DECISION DELEGATED TO DEVELOPMENT MANAGER

Application No: H13-0130-20 **Applicant:** Mr M Ogunade
Proposal: Front porch extension, garage conversion and creation of rear dormer
Location: 7 Benton Close Moulton Chapel Spalding
Terminal Date: 20th October 2020

Notes:
 All dimensions to be checked on site by the contractor prior to setting out or fabrication of components.
 The contractor is not to scale dimensions off this drawing.
 No measuring survey carried out by TAD Studio.
 This drawing shall not be reproduced without written authority.

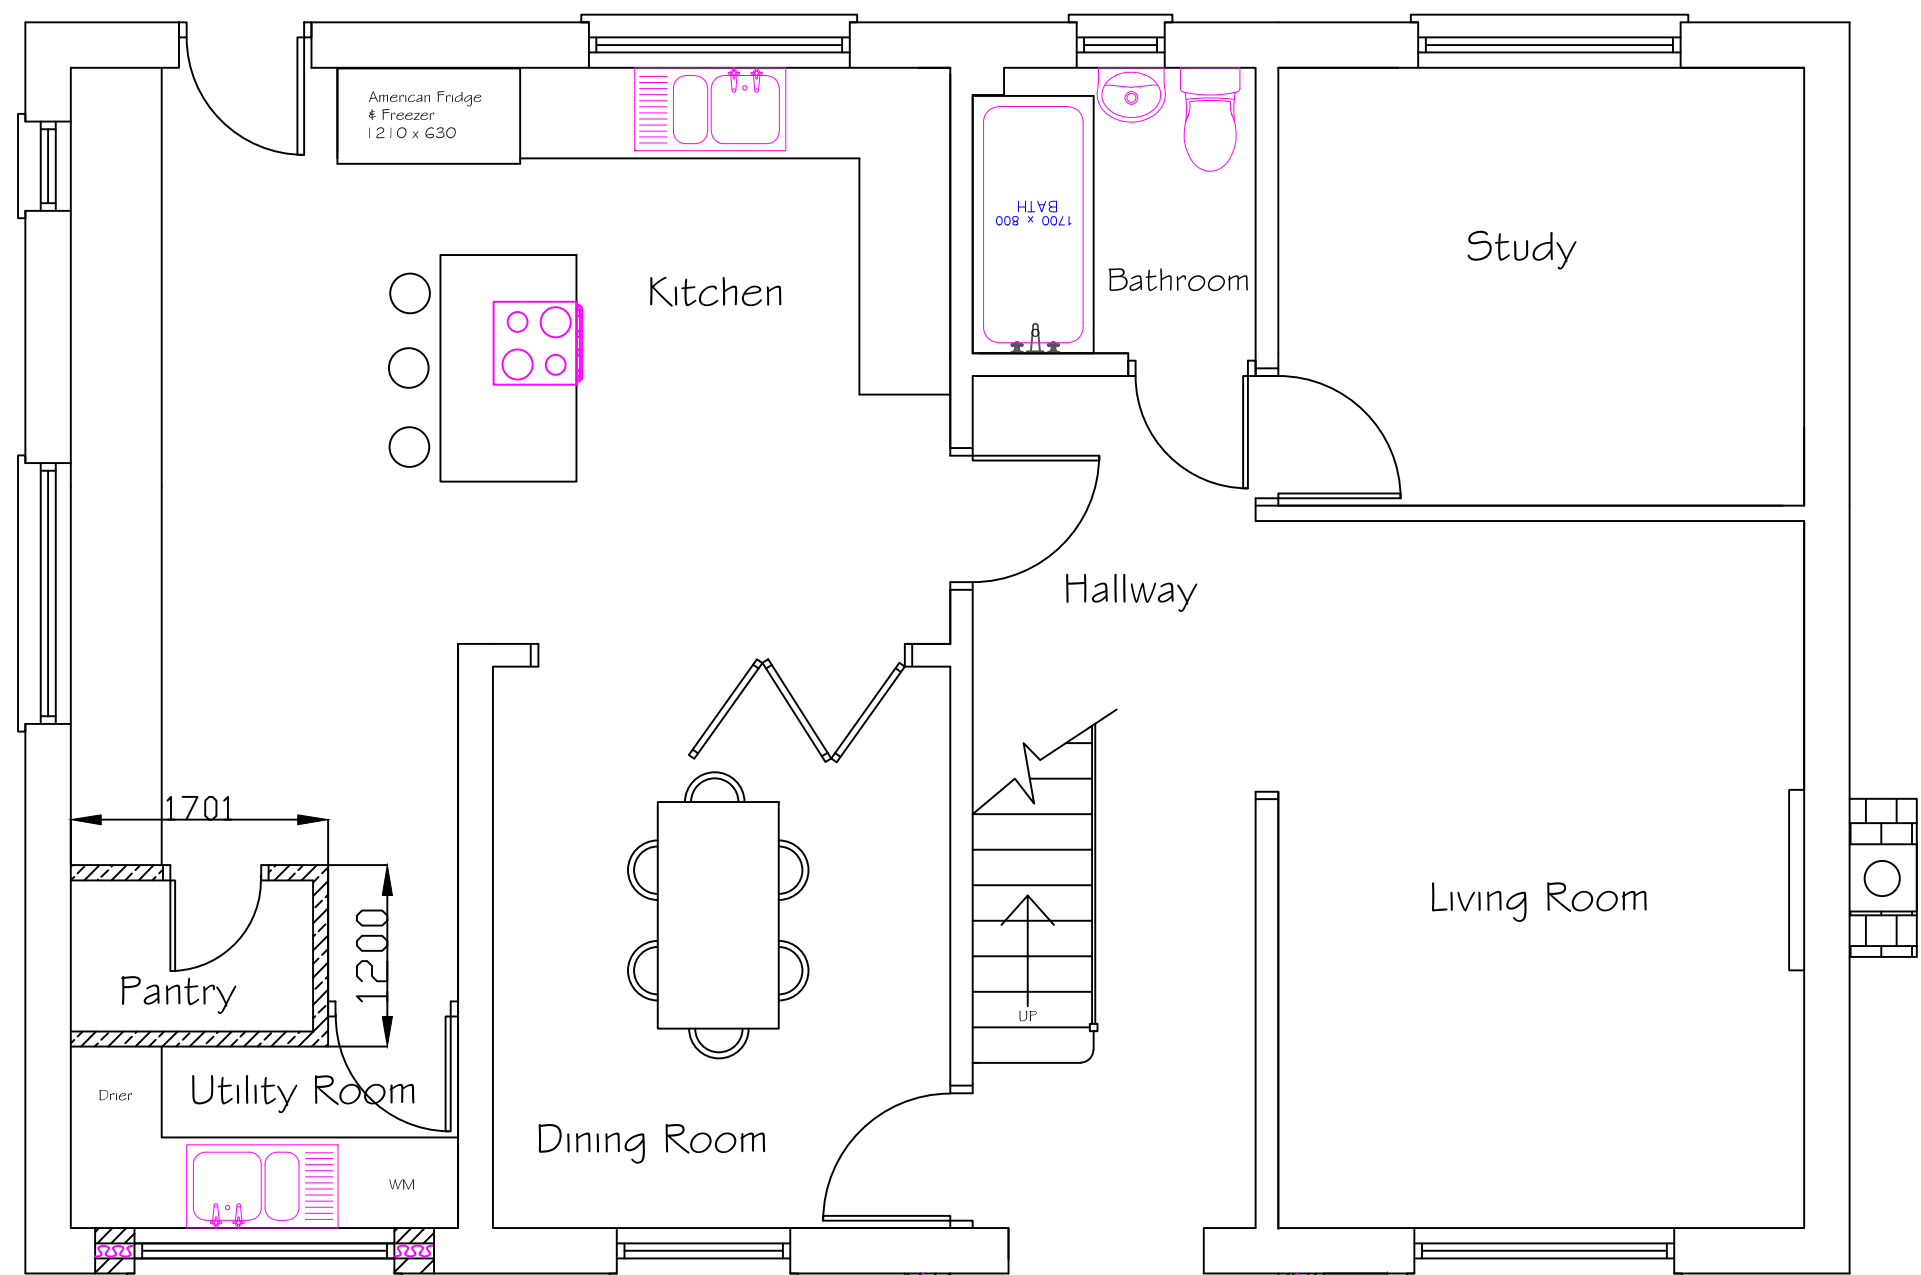
The rear dormer will be set back approximately 65 centimetres from the outer edge of the eaves, and 80 centimetres from the gable pitch of the dwelling. It will extend nearly the full width of the roof slope. The form of development is such that the rear dormer will be subservient to the host property

The front porch will be bricked in all external elevations. A hip roof will be on top of the porch which will provide further variety to the mixture of gable pitches on front dormer windows and shed roof on the rear dormer. Formerly, the proposals include a box style rear dormer. The revised plans have replaced the flat roof for a shed roof which will avoid an eyesore and contribute to soften the sharpness of the form of development and, ultimately, deliver a high quality designed loft conversion.

There have been objections received during the consultation process. The main issue is the potential overlooking effect from the windows of the proposed rear dormer to the adjacent rear gardens. It worth mentioning that the property currently has roof lights on the rear roof slope which might already lead to somewhat overlooking effect. In fact the proposed windows will be larger than the existing roof lights even though the field view and angle of vision will be similar. The loft users will have still restricted vision to both sides (gardens of properties at No. 6 and 8) and direct views onto the rear gardens of properties at Roman Road.

However, the direct views would not create a significant loss of privacy neither in the exterior amenity areas nor habitable spaces. The garden of the application property is approximately 10 metres long and the lengths of rear gardens of properties No. 30, 32 and 34 Roman Bank are in the region of 30 metres. Furthermore, the nearest and approximate distances between the rear dormer windows and the rear elevations of No. 30, 32 and 34 Roman Bank are 43, 34 and 33 metres respectively.

The shed roof for the rear dormer is well-regarded in comparison with the formerly proposed box dormer. Although some concerns on overlooking effect from the intended dormer, the field view from the new openings and existing separation distances with properties to the south will not entail any exacerbation of overlooking effect respecting the current roof lights on the rear roof slope.

with the agent, revised plans were submitted showing a shed roofed dormer. The number of four windows remains.
